**From:**  
**Sent:** 31 August 2026 18:16  
**To:** DC Admin; James Evans  
**Subject:** 2026/91900 – further discrepancy in amended plans

Proposed Ground Floor Plan

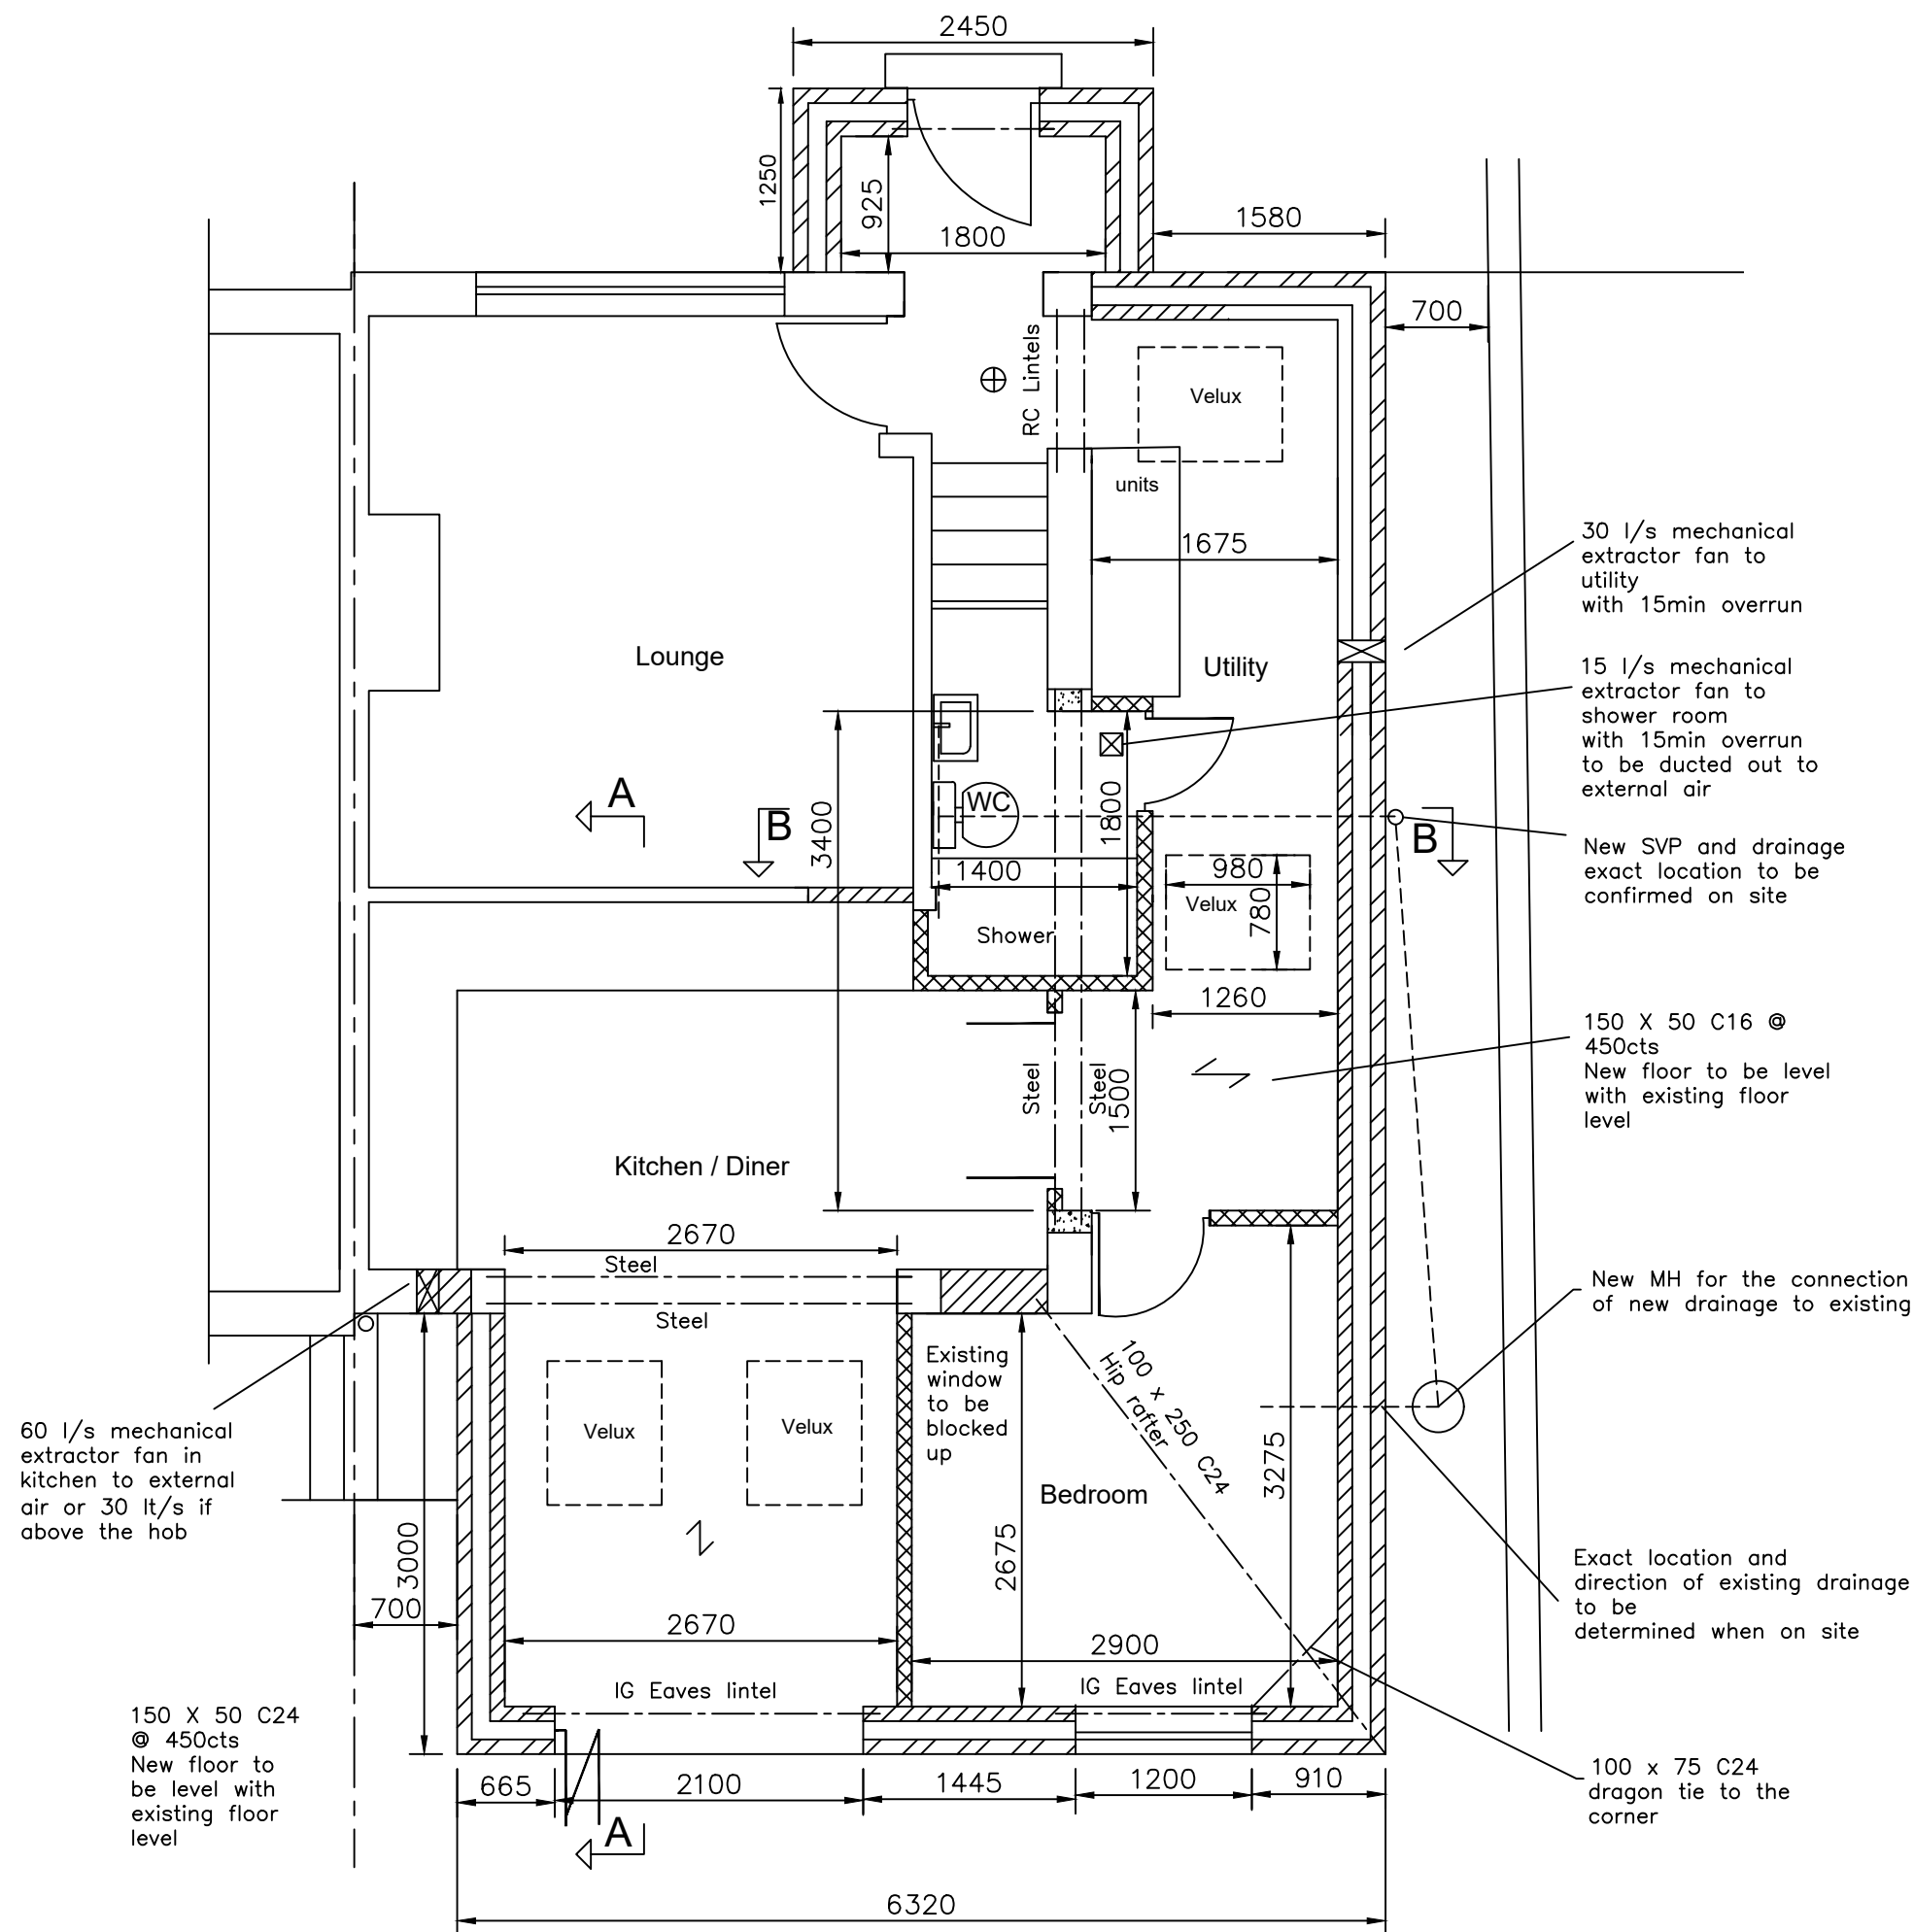
The site plan continues to identify the access as 700mm, whereas the subsequent amended drawings appear to show an increased width of 800mm/900mm. This is in addition to the discrepancies I have already raised regarding the existing gate, steps and recessed landing.

Proposed Site Plan

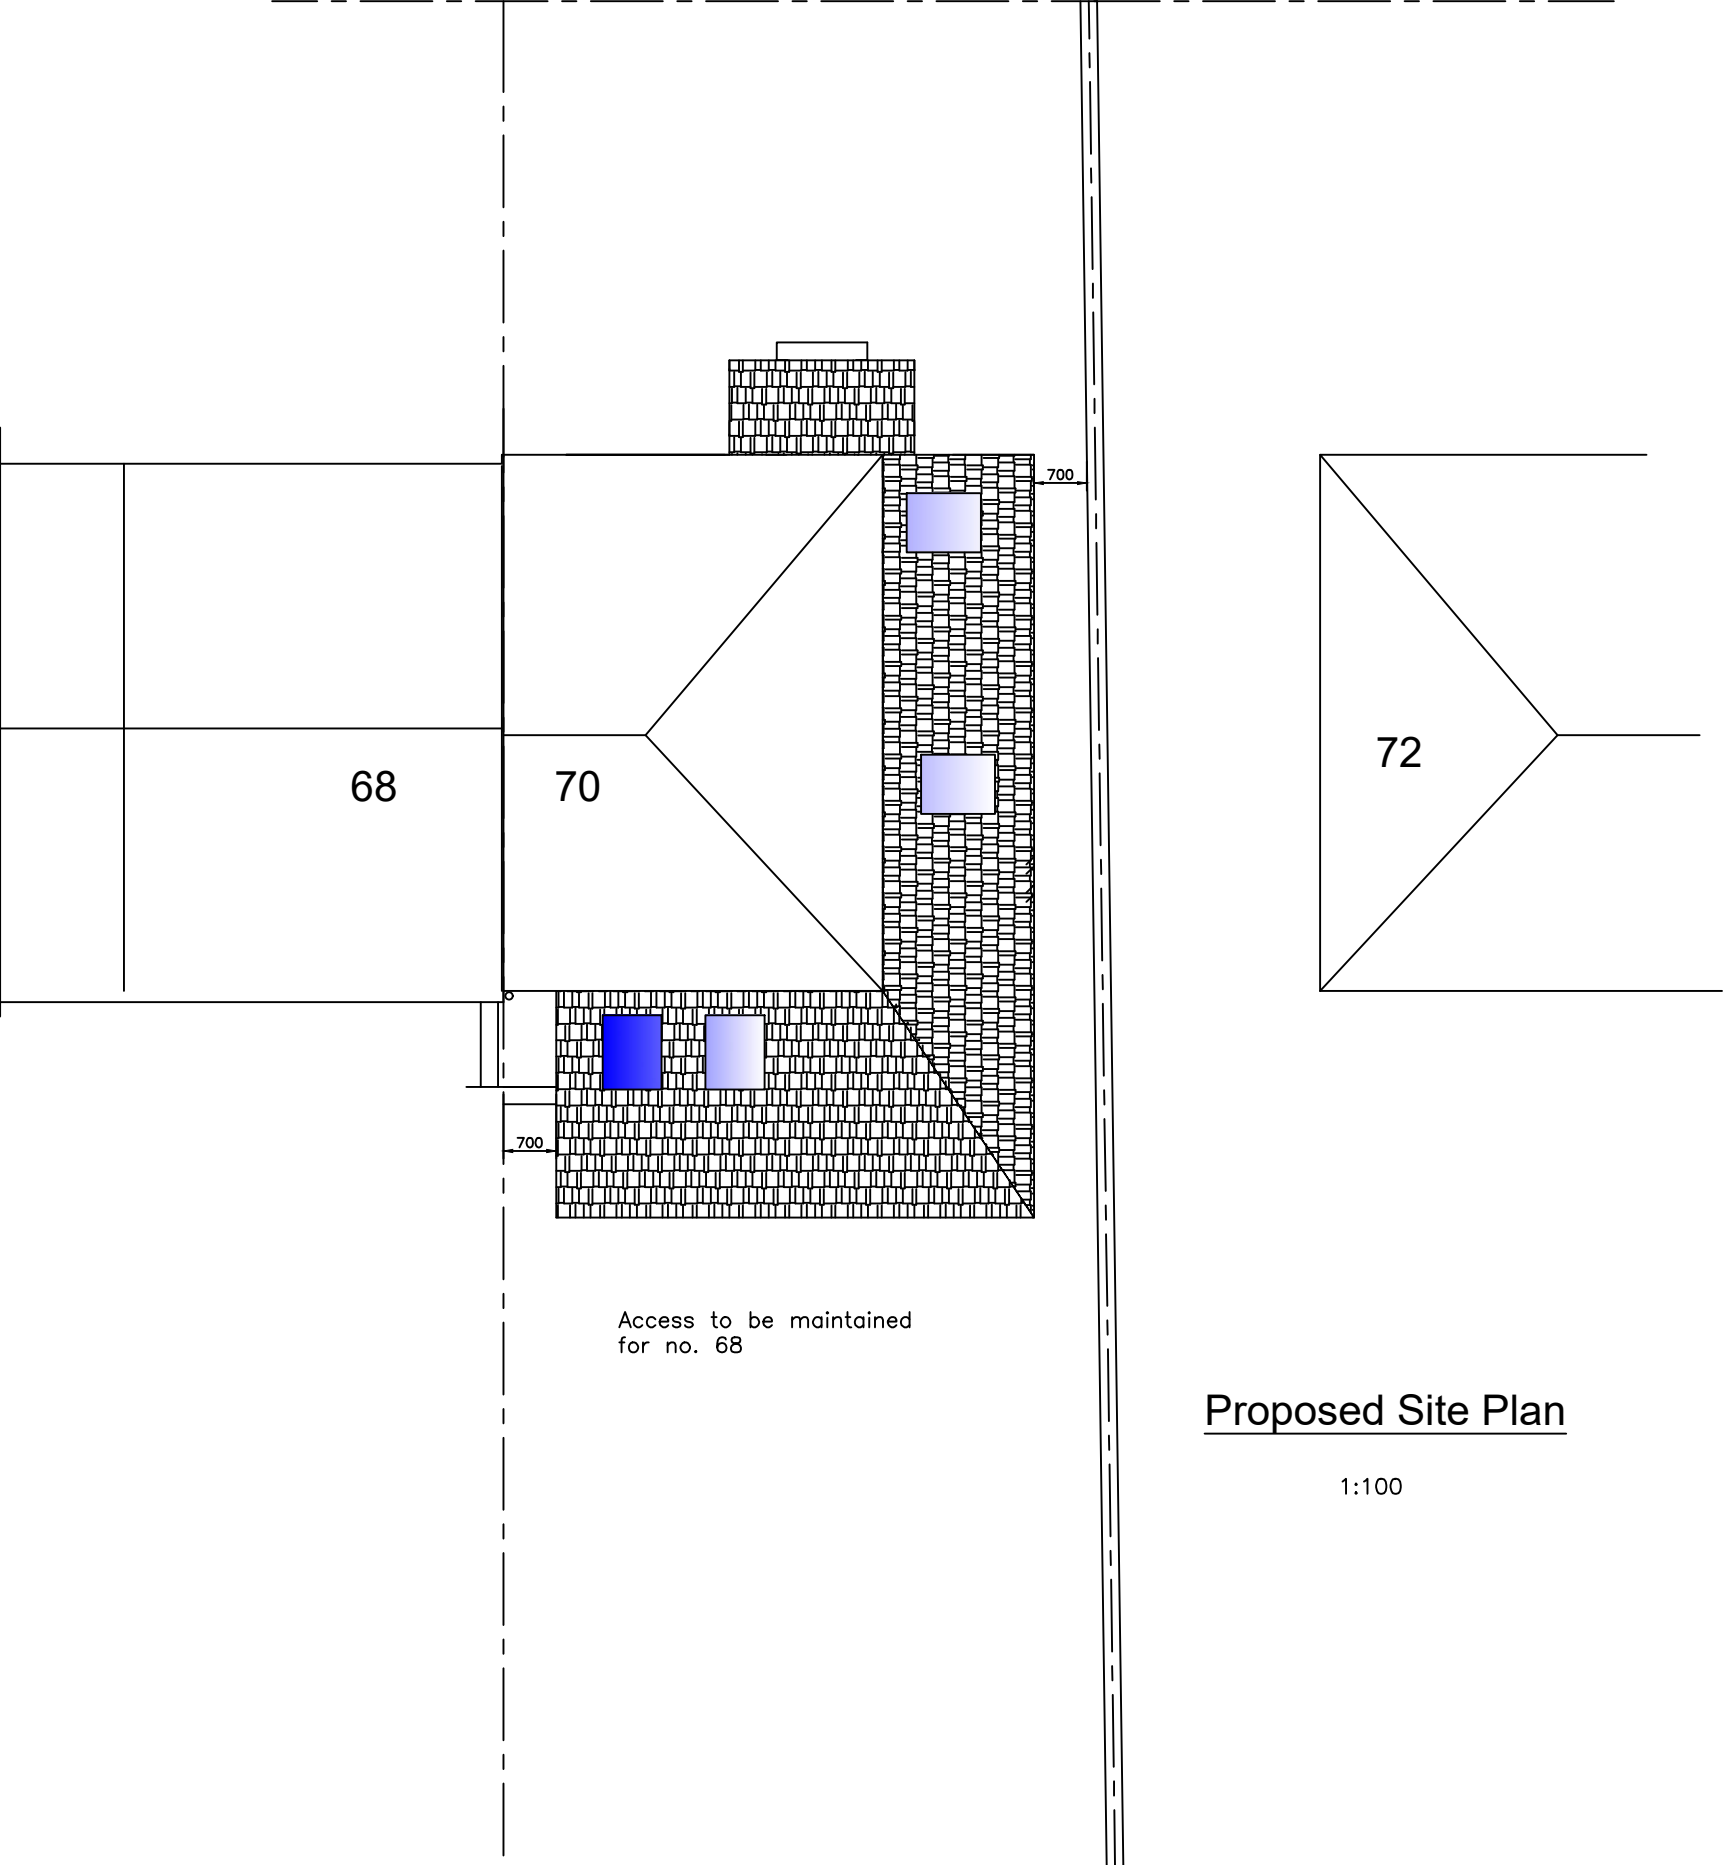
In particular, could you please confirm which plan/measurement is being relied upon when assessing the proposed access?
